City of Charlotte – Planning Dept. Scanning Rezoning Files

SUBJECT: Petition No. 89-21

SUBJECT: Rezoning Petition #89-21

SUBJECT: Rezoning Petition 89-21: 0.08 acres on Piney Grove Road
near Idlewild Road

**Site Plan**

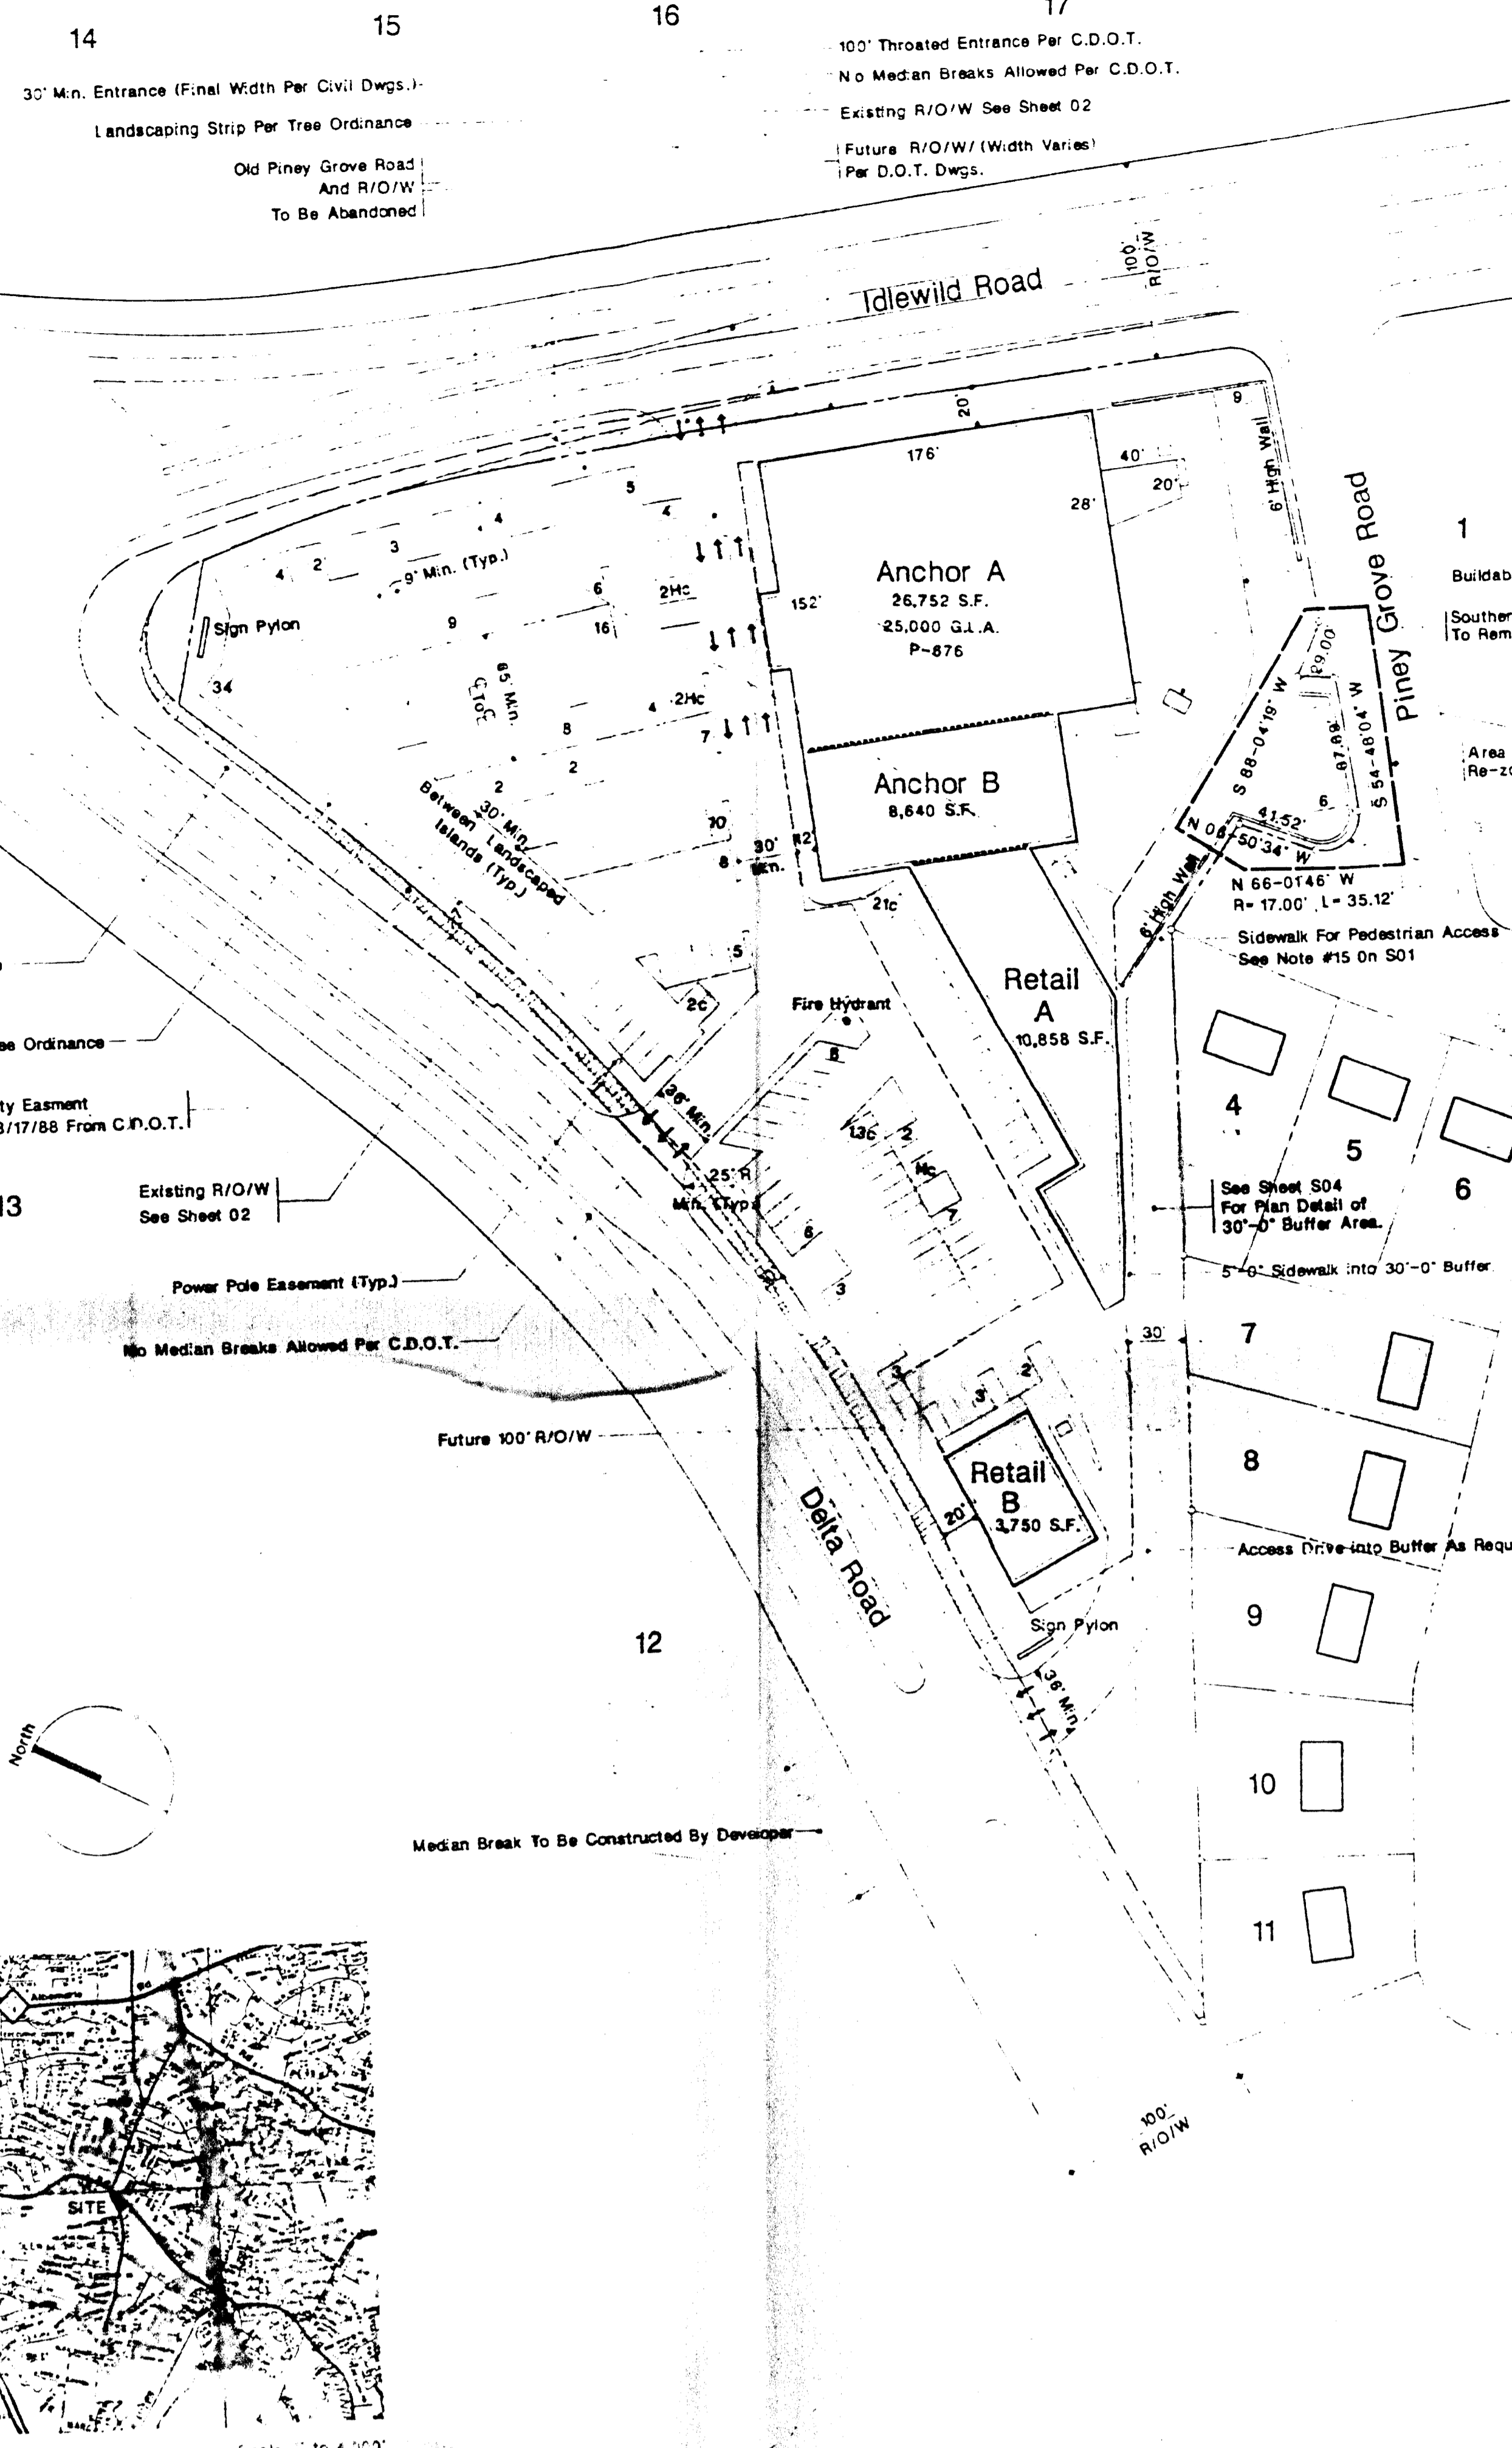
Under Rezoning Petition 88-53 a left turn lane at the southernmost driveway was required at a proposed median opening. The petitioner does not show the required left turn lane on the site plan. Construction of the left-turn lane and the median opening are the responsibility of the developer.

Adequate sight distance should be reserved at the proposed entrances. Two 10' x 70' sight triangles are required for the entrances to meet sight distance requirements. All proposed trees, berms walls, fences, and/or identification signs should not interfere with sight distance at the entrances. Such items should be identified on the site plan.
